Recommendation Report for Planning Permission for Works or Extension to a Dwelling

REF NO: Y/41/21/HH

LOCATION: Ferndale House
 Burndell Road
 Yapton
 BN18 0HT

PROPOSAL: Demolition of single storey side extension and two storey rear extension. Erection of new two storey side / rear extension. Insertion of projecting rear dormer window and rooflights to front and rear. Erection of front boundary low wall and gates.

1308/ PL-07

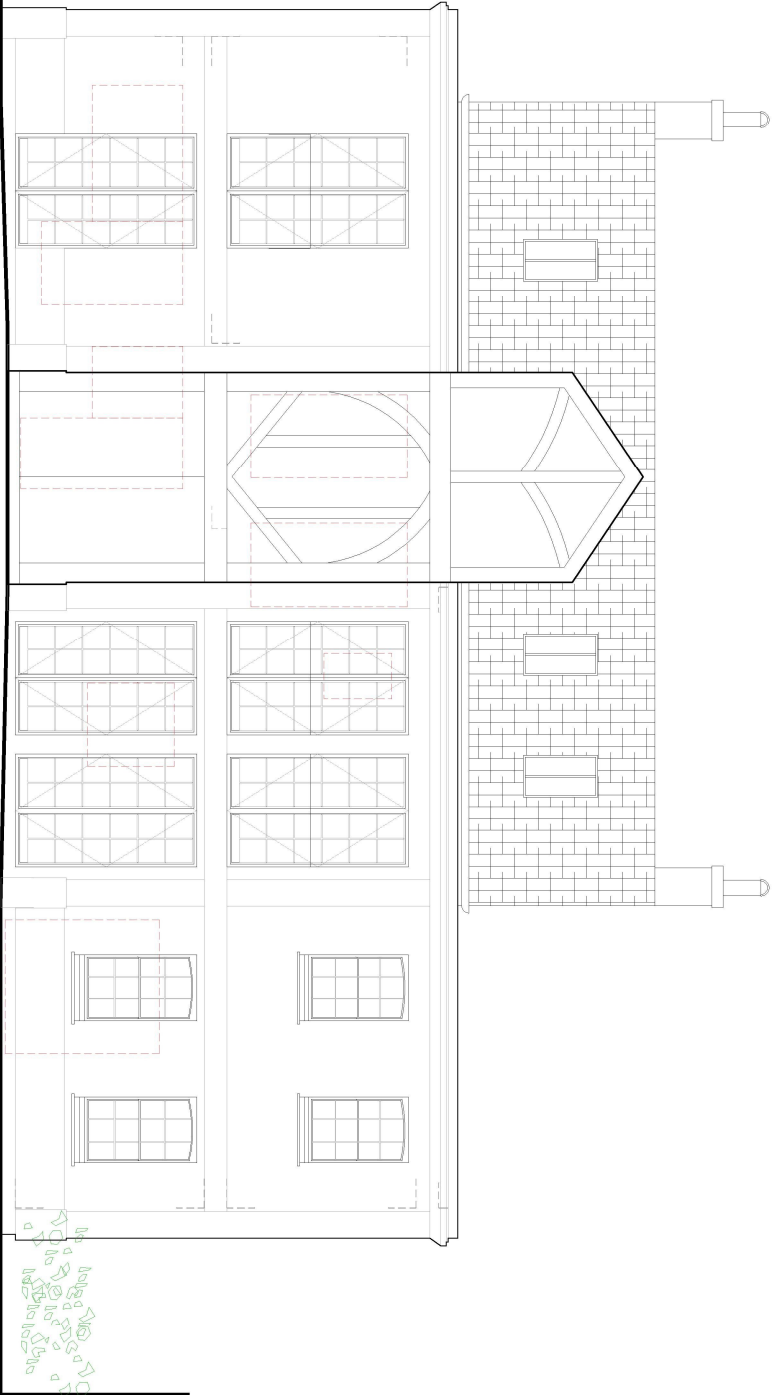
The large scale of this development had resulted in issues relating to the close proximity to the boundary, leaving only 2.1m to the boundary. This is not enough to avoid the overbearing and overlooking impact on the neighbouring property. Furthermore the proposed scheme is considered to cause overshadowing of the neighbour resultant of the lack of distance between the proposal and the boundary. Due to the large scale and design of the extensions they do not appear subservient to, or well integrated with the dwelling which is a locally listed building.

Section M, referring to householder extensions states extensions should respond to and complement the existing character and appearance of the building and wider townscape in terms of scale, massing. It is considered this is not achieved through this scheme, with the addition significantly harming the host dwelling.

The proposal results in a harmful impact on the host dwelling, and as such, it conflicts with D DM1, D DM4(a), (b) and (e) and HER DM2 of the Arun Local Plan and J.01 of the Arun Design Guide which outlines that built form and character varies considerably throughout the Arun District as a whole and within the settlement character areas identified in section C.06 of the Design Guide.

1308/ PL-09

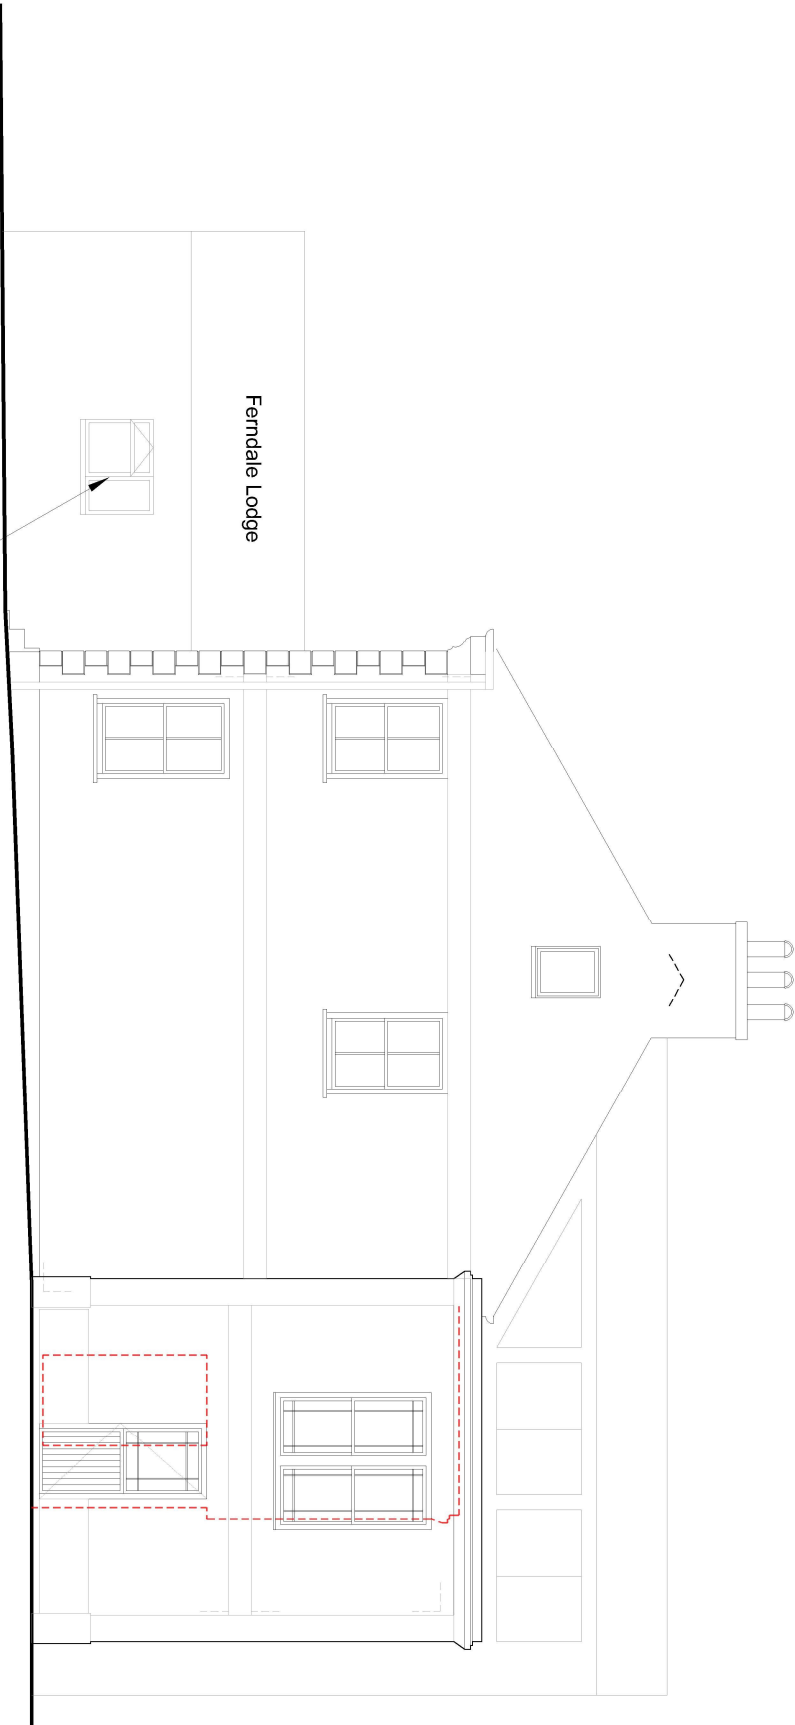
This proposal is to the side and rear of the locally listed building. The neighbouring property is located close to the west boundary, with the extension encroaching to within 2.2m of the boundary this will have an impact on the neighbouring property. The new side extension is a significant extension which creates a lot of bulk to the side and rear of the dwelling.

The large scale nature of the proposal is considered to cause an overbearing impact to the neighbouring property to the west. This is due to the significant increase in height near the boundary and the single storey nature of the neighbouring property. Whilst there is some screening on the boundary which will mitigate some of the overlooking and overbearing the boundary foliage is not considered to reduce the level of impact to an extent which would be cause for the application to be approved.

Part M of the Arun Design Guide explains that proposals should preserve the amenity of the original and neighbouring property in regards to overlooking, overbearing and overshadowing. The proposal of is considered to conflict with this due to the separation distance, design and the scale of the proposed.

- 1 The development due to the height, length and siting and size resulting in an unneighbourly and unacceptable overbearing effect on the occupiers Ferndale Cottage contrary to policies D DM1 and D DM4 of the Arun Local Plan.
